Consultation Response from KC, Highways Development Management		
2020/93007 former Public Conveniences, Westbourne Road, Marsh, Huddersfield, HD1 4LF		
Change of use of former public conveniences to Class E retail shop with erection of single storey extension		
Date Responded: 09/11/2020	Responding Officer: Zack Turner	Responding Ref: K5-2SE/25

Proposed Site Plan
Scale: 1 : 200

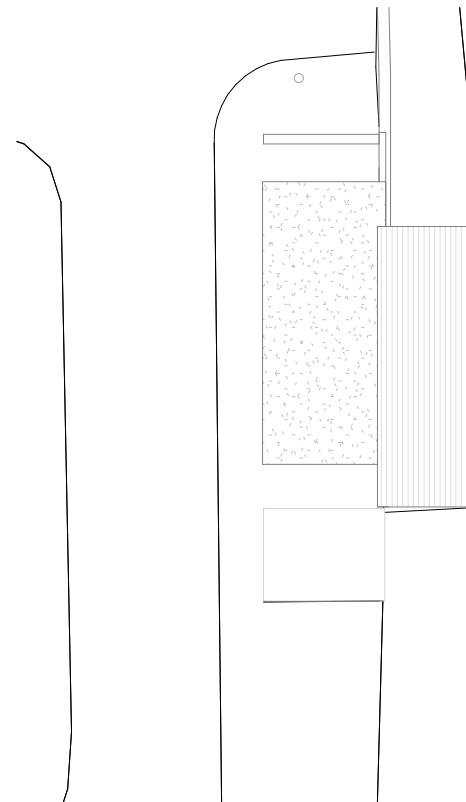
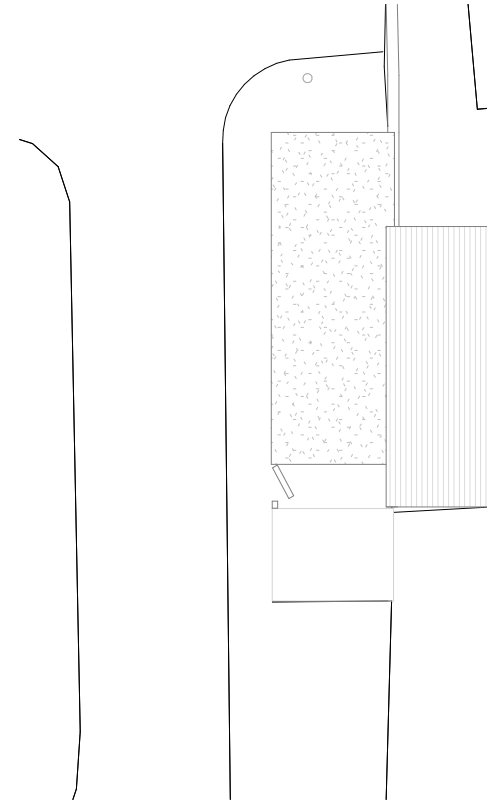
Waste storage and collection arrangements are provided on the plan to the south of the site.
